Our Ref: M/126/17/HH
Your Ref:

Town & Country Planning Act 1990 (as amended)
Town & country Planning (Development Management Procedure) (England) Order 2015
Application for Planning Permission for Works or Extension to a Dwelling

Development Single storey extensions to East, South & West elevations & loft conversion.
Location 7 Alleyne Way Elmer Middleton on Sea

Drawing Title:
PROPOSED FLOOR PLANS AND ELEVATIONS

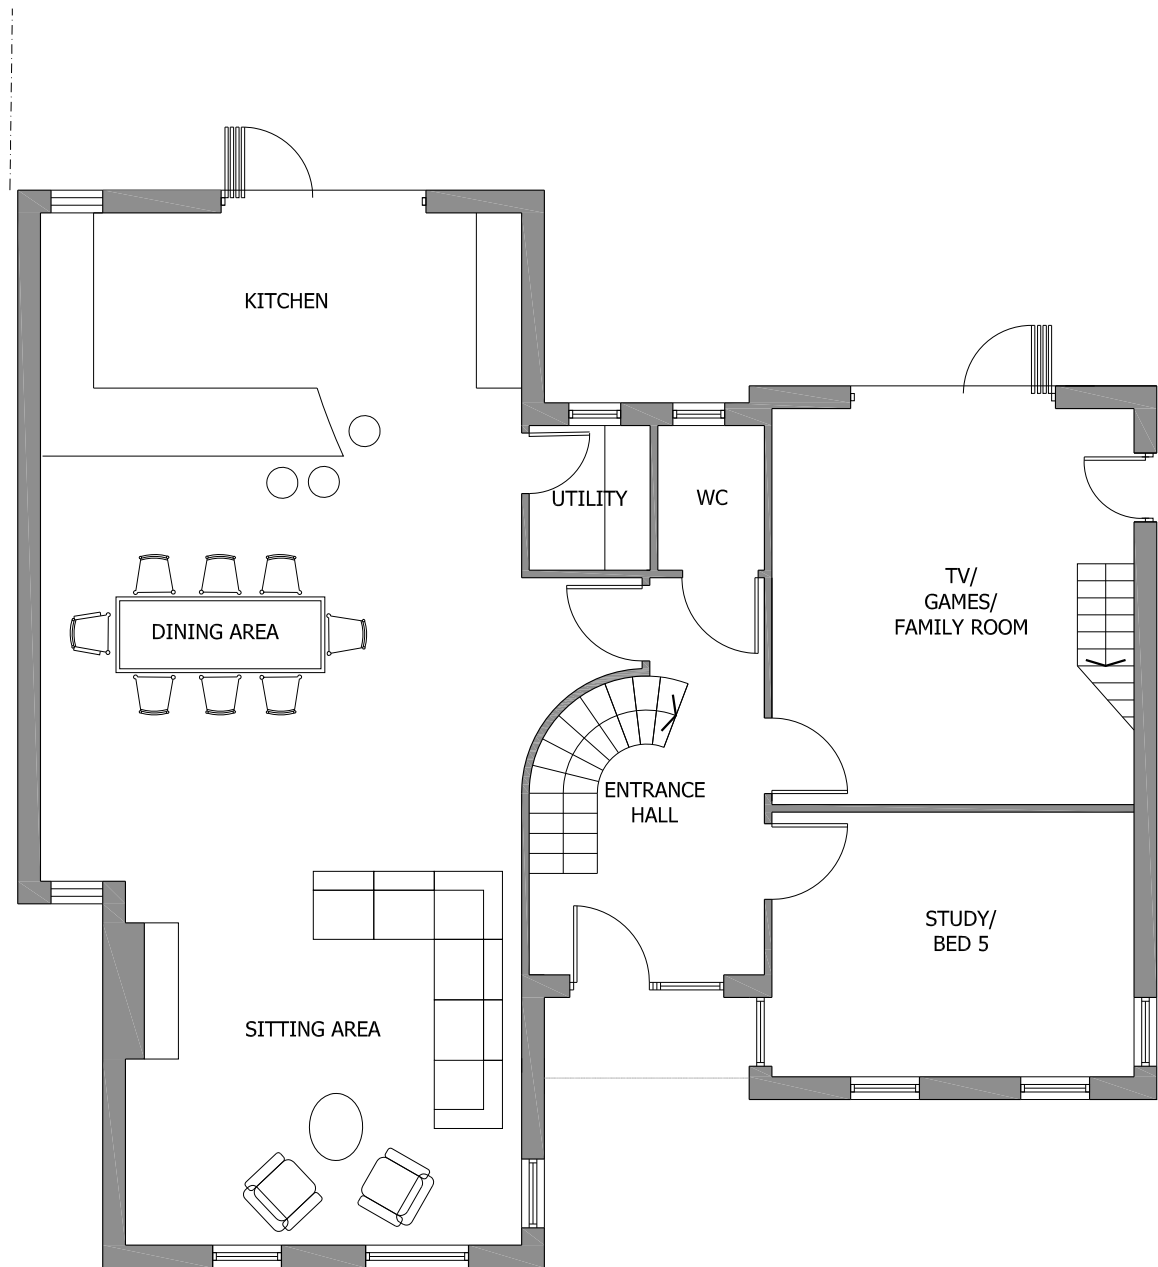
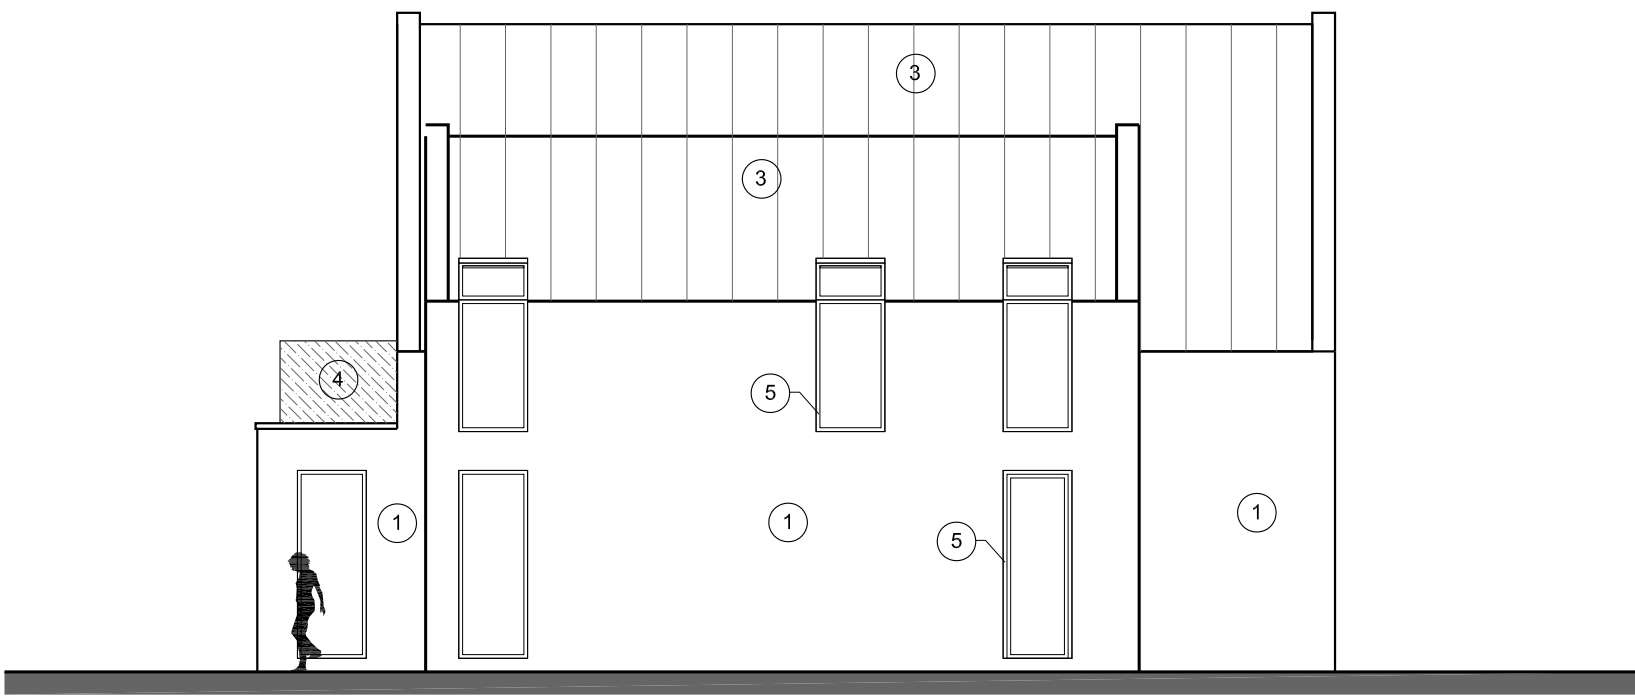
The proposed ground floor plan and south elevation do not accord. Please amend accordingly.
